Iascach Intíre Éireann  
Inland Fisheries Ireland

**12<sup>th</sup> May 2022**

**SHD 313338:** 207 no. Build to Rent apartments. Junction of Ravens Rock Road and Carmanhall Road, Sandyford, Dublin 18.

**Applicant:** Sandyford Environmental Construction Ltd

TITLE PROPOSED FOUL & SURFACE WATER DRAINAGE OUTFALLS

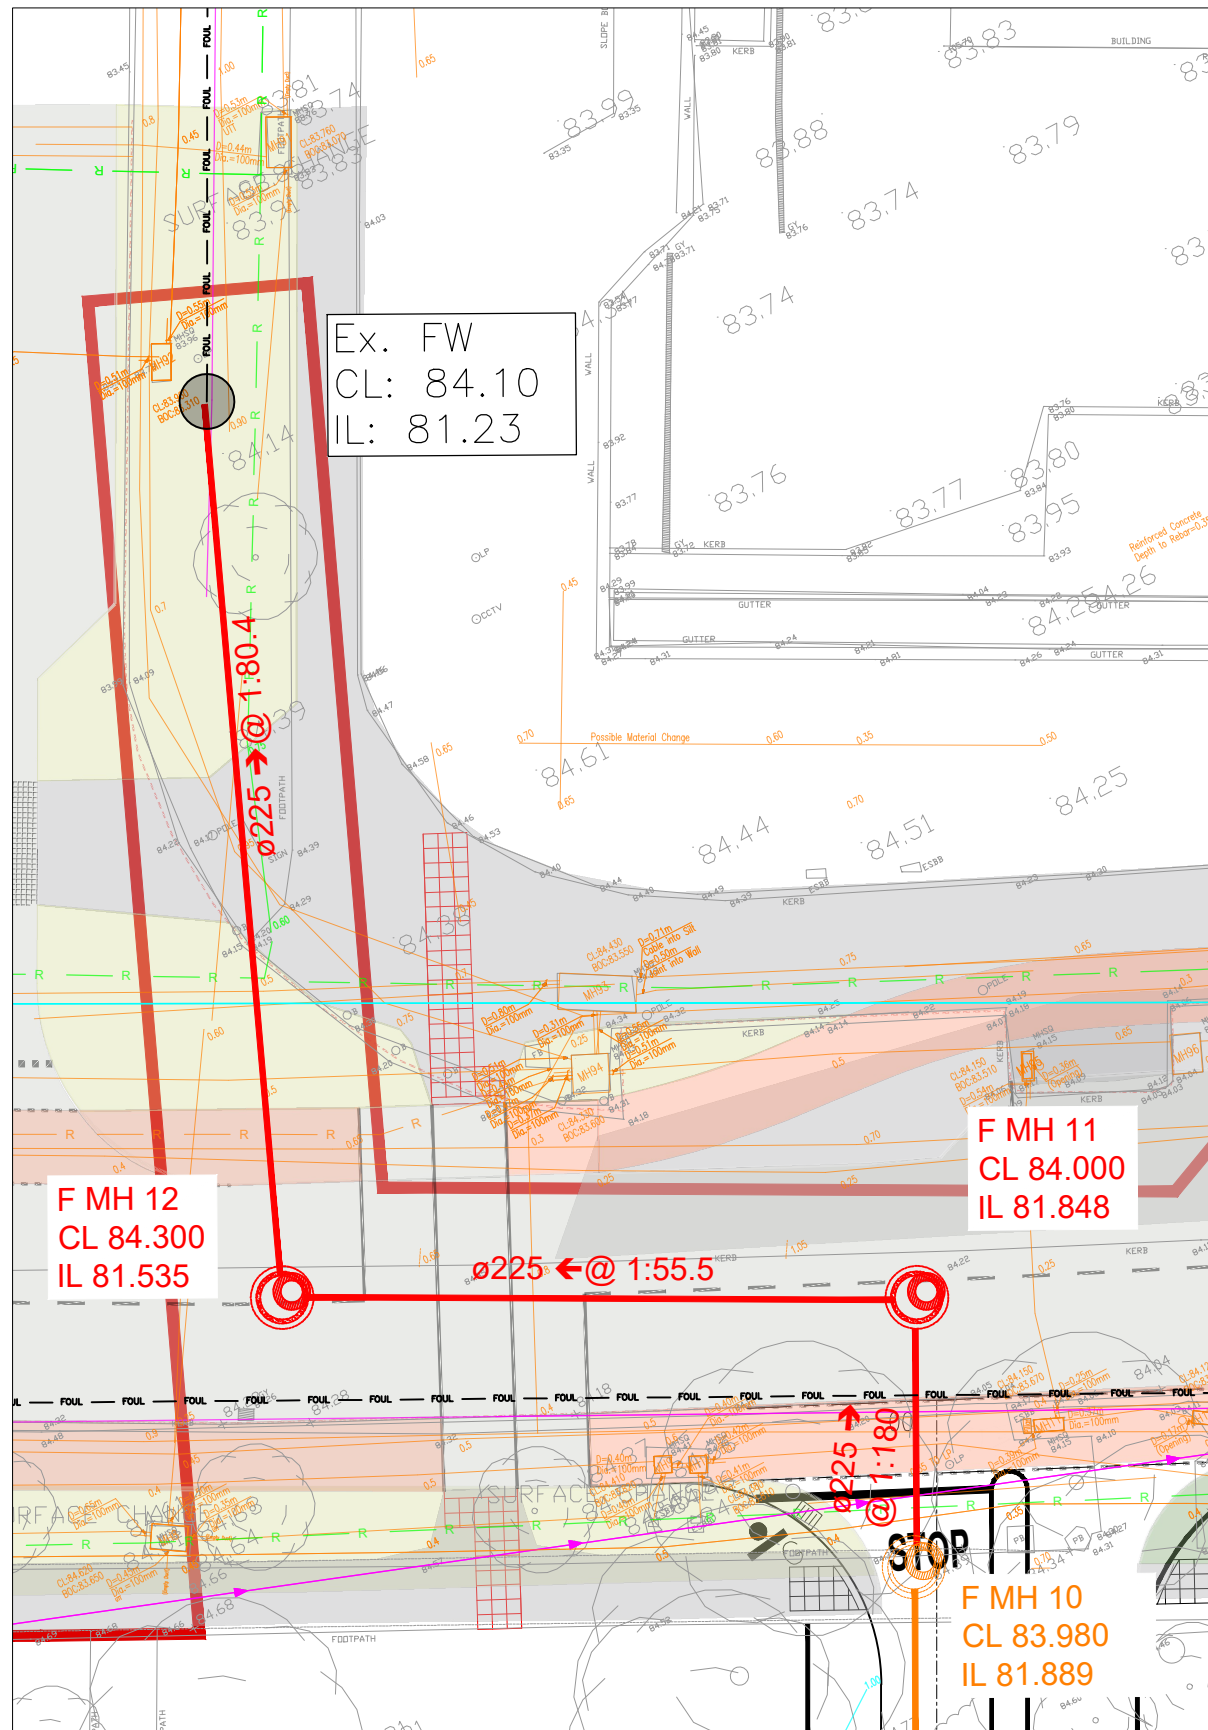
- The developer must take adequate precautions to ensure there is no entry of solids, during the connection of pipework, to the existing surface water system.

- It is essential that the receiving foul and storm water infrastructure has adequate capacity to accept predicted volumes from this development during construction and post construction phases with no negative repercussions for the quality of any receiving waters. Ringsend WWTP is currently working at or beyond its design capacity and won't be fully upgraded until 2023.

TITLE **PROPOSED SURFACE WATER ATTENUATION DETAILS**

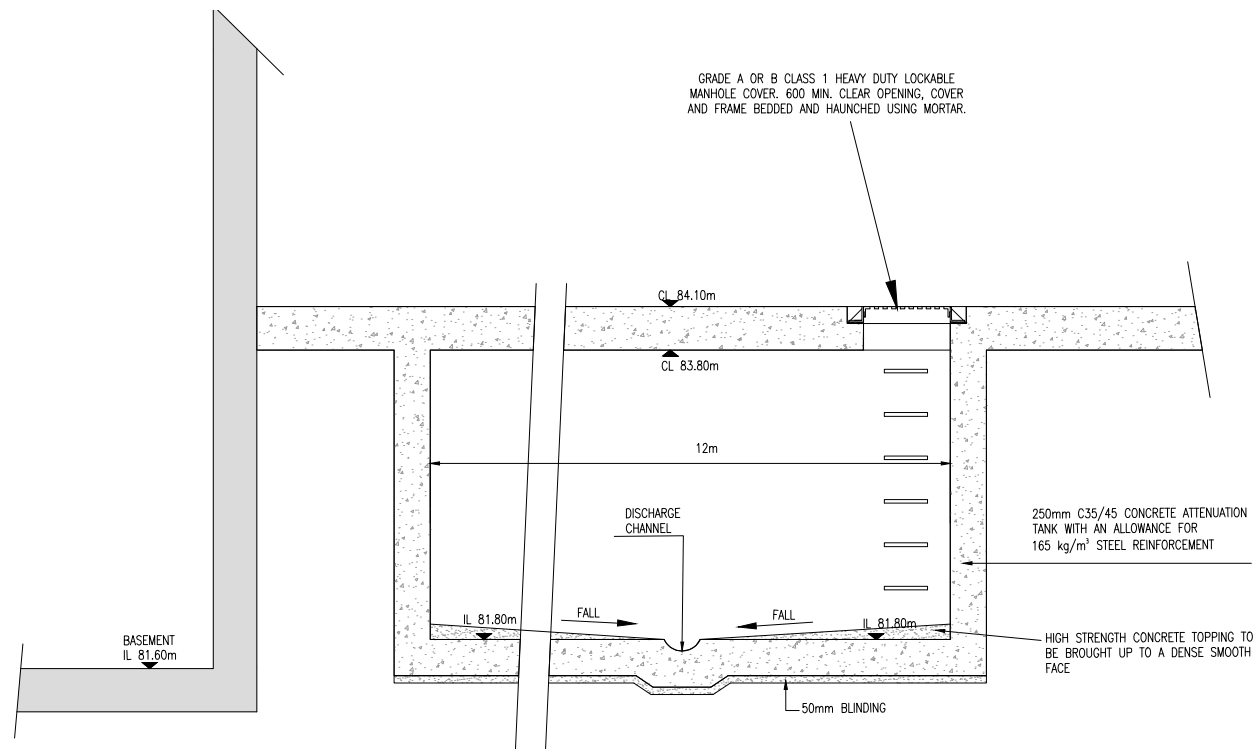
IFI are becoming more aware of the lack of appropriate maintenance on interceptors, attenuation tanks on some developments in the operational phases and would encourage that the appointed site management/maintenance company, post construction phase be required to enter a service maintenance contract with an authorised specialised company with responsibility for the maintenance of this same infrastructure.
